Planning Services Sign Permit Review Form

Date of Submittal	Application Number	Applicant	Landowner
10/26/2023	SIGN2310-0005	TMTLA Associates	DRB Group North Carolina LLC.

Contact Person	Contact Number	PIN Number	
Robin@tmtia.com	919-484-8880		
Sign Location	2 Signs Corner of Sheriff Johnson Rd. and Bronze Leaf Dr.; Lots 88 and 89.		0680-38-7921.000 0680-38-8753.000

1 SIGN LOCATION PLAN A
SCALE: 1"=20'

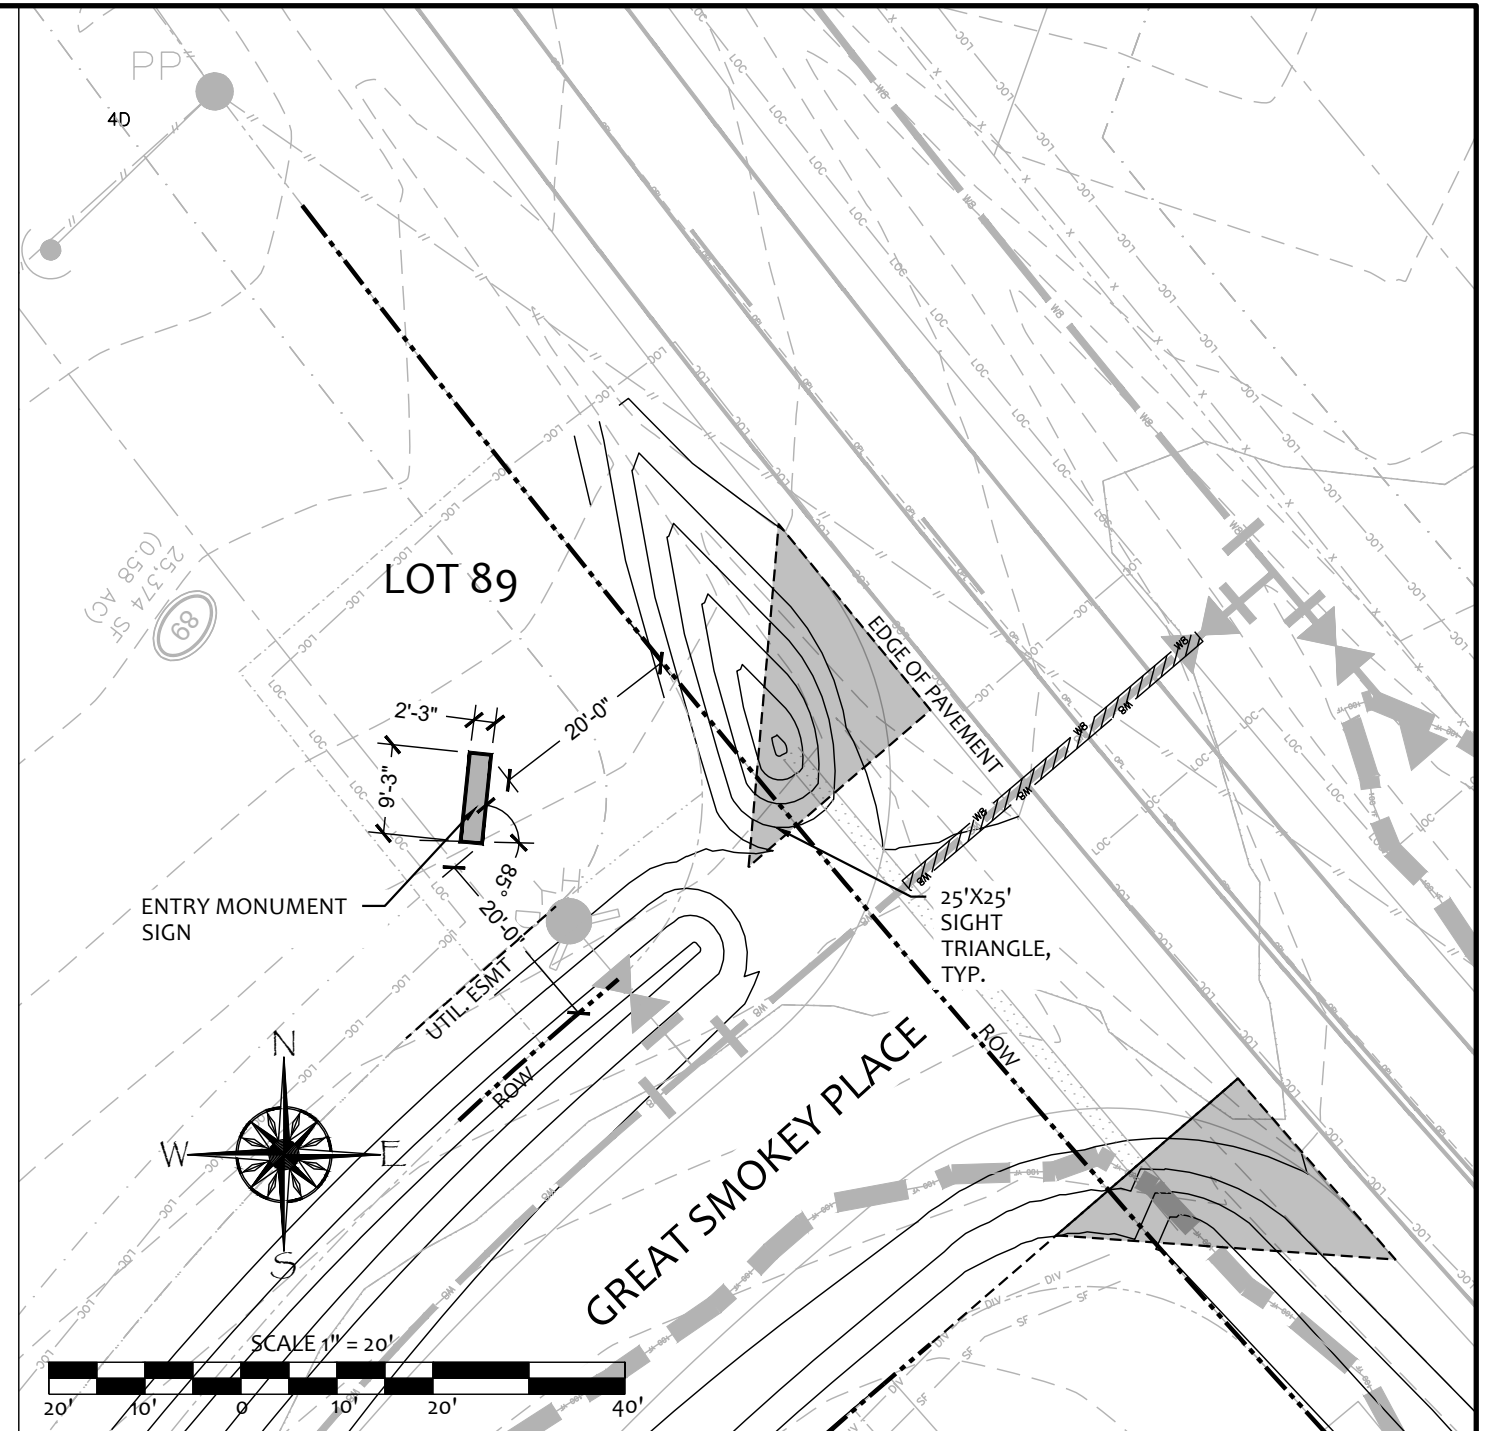
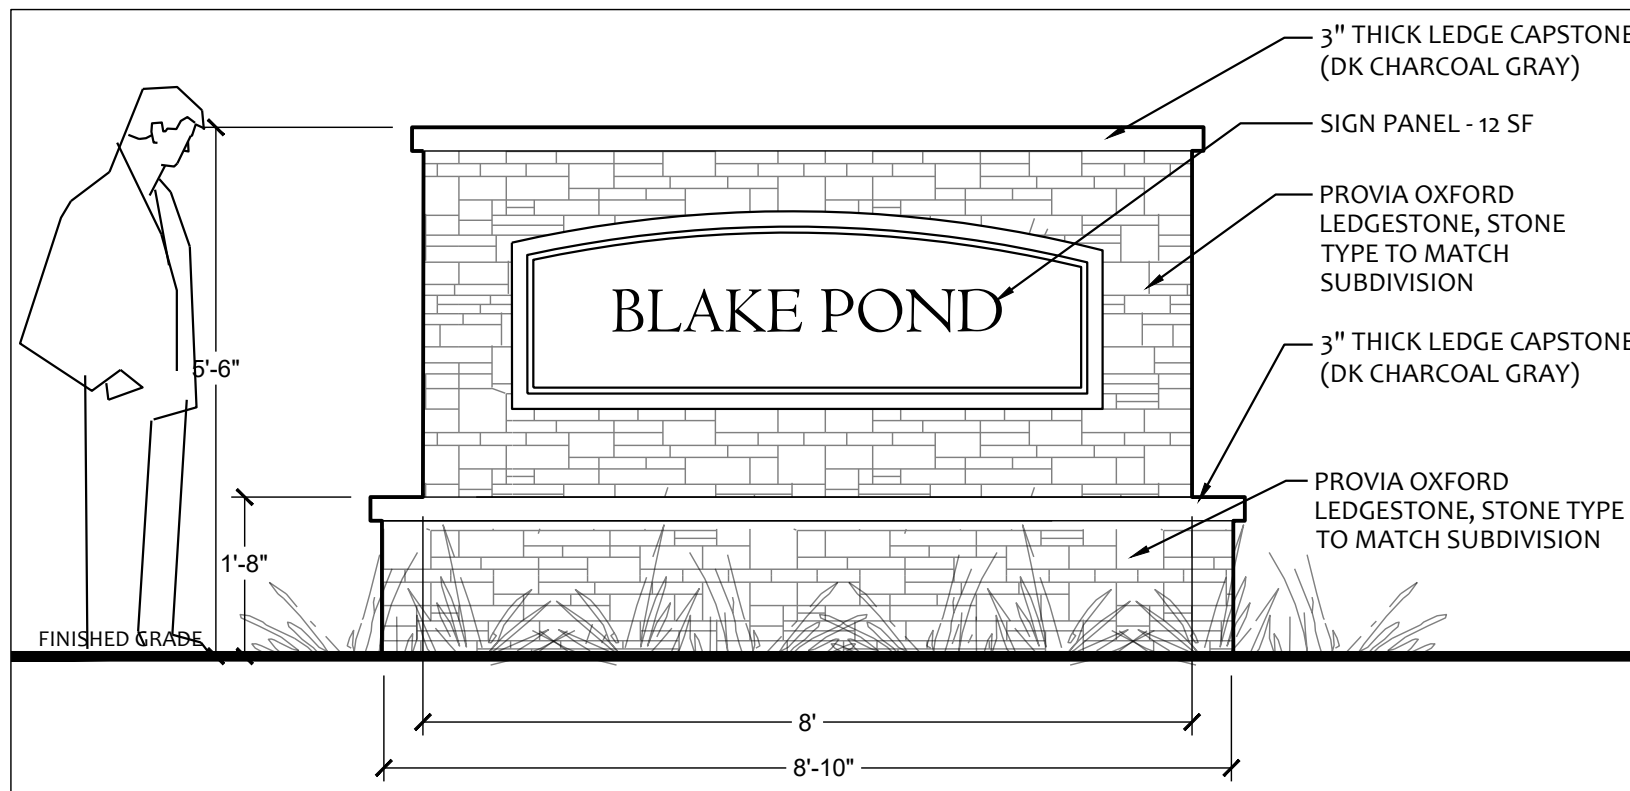
Comments	
	1. When signs are constructed at an intersection, the minimum setback is 20' from each ROW. Please revise the location of the sign on the site plan.
